CITY OF ALBUQUERQUE

February 17, 2017

RE: 7001 Signal Ave. Allergy Clinic
Grading and Drainage Plan
Engineer's Stamp Date 1-31-2017 (File: C19D065)

7001 SIGNAL AVE. N.E. - ALLERGY CLINIC  
GRADING AND DRAINAGE PLAN  
FOR INFORMATION ONLY

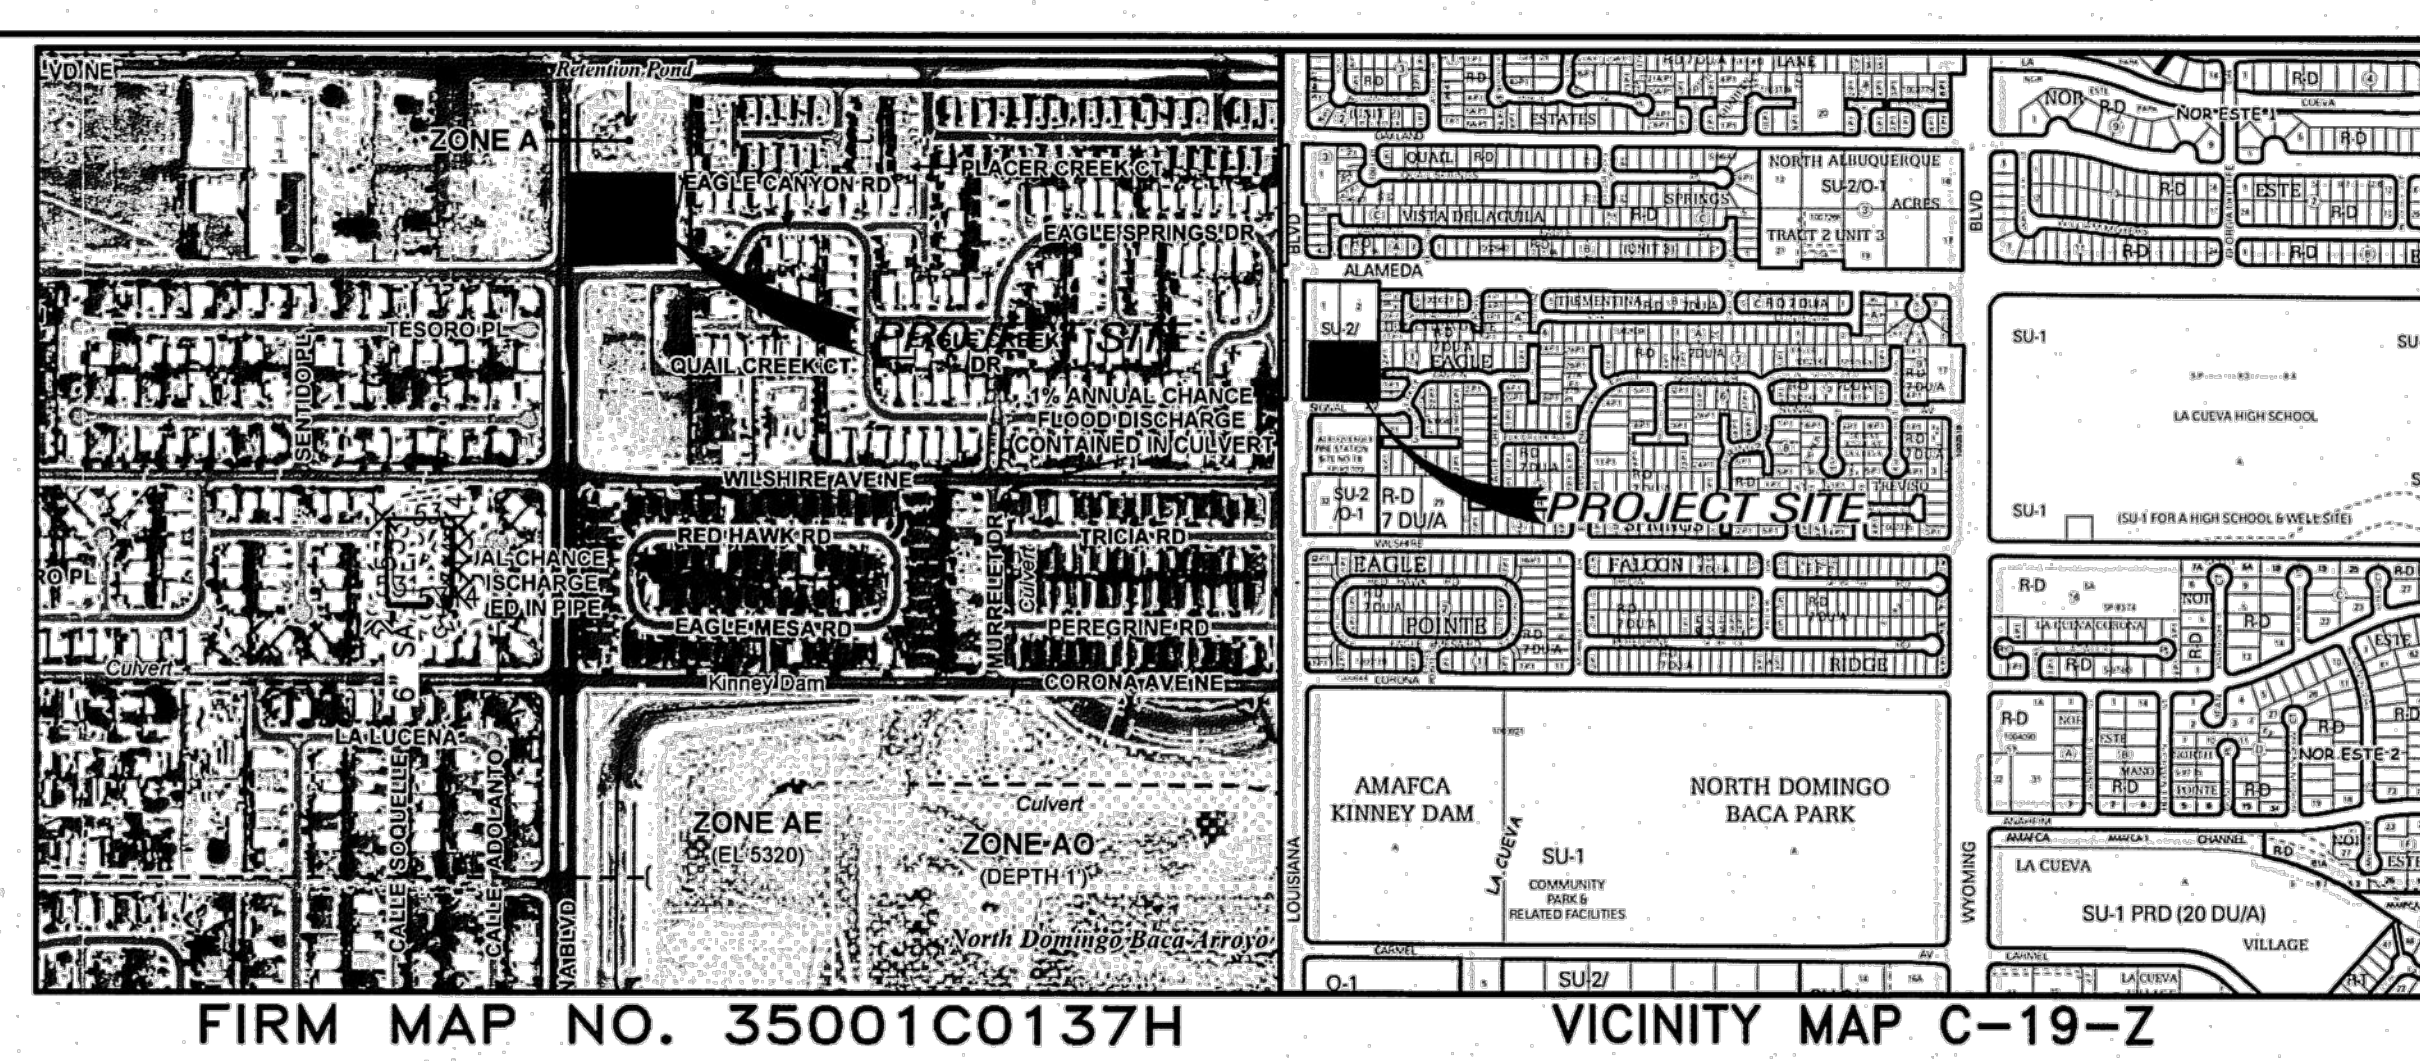
1. Extend the sidewalk culvert plus plate 12 inches passed property line.
2. Please make sure sign shown at the southwest corner of Louisiana and Signal will not create clear sight distance issues.
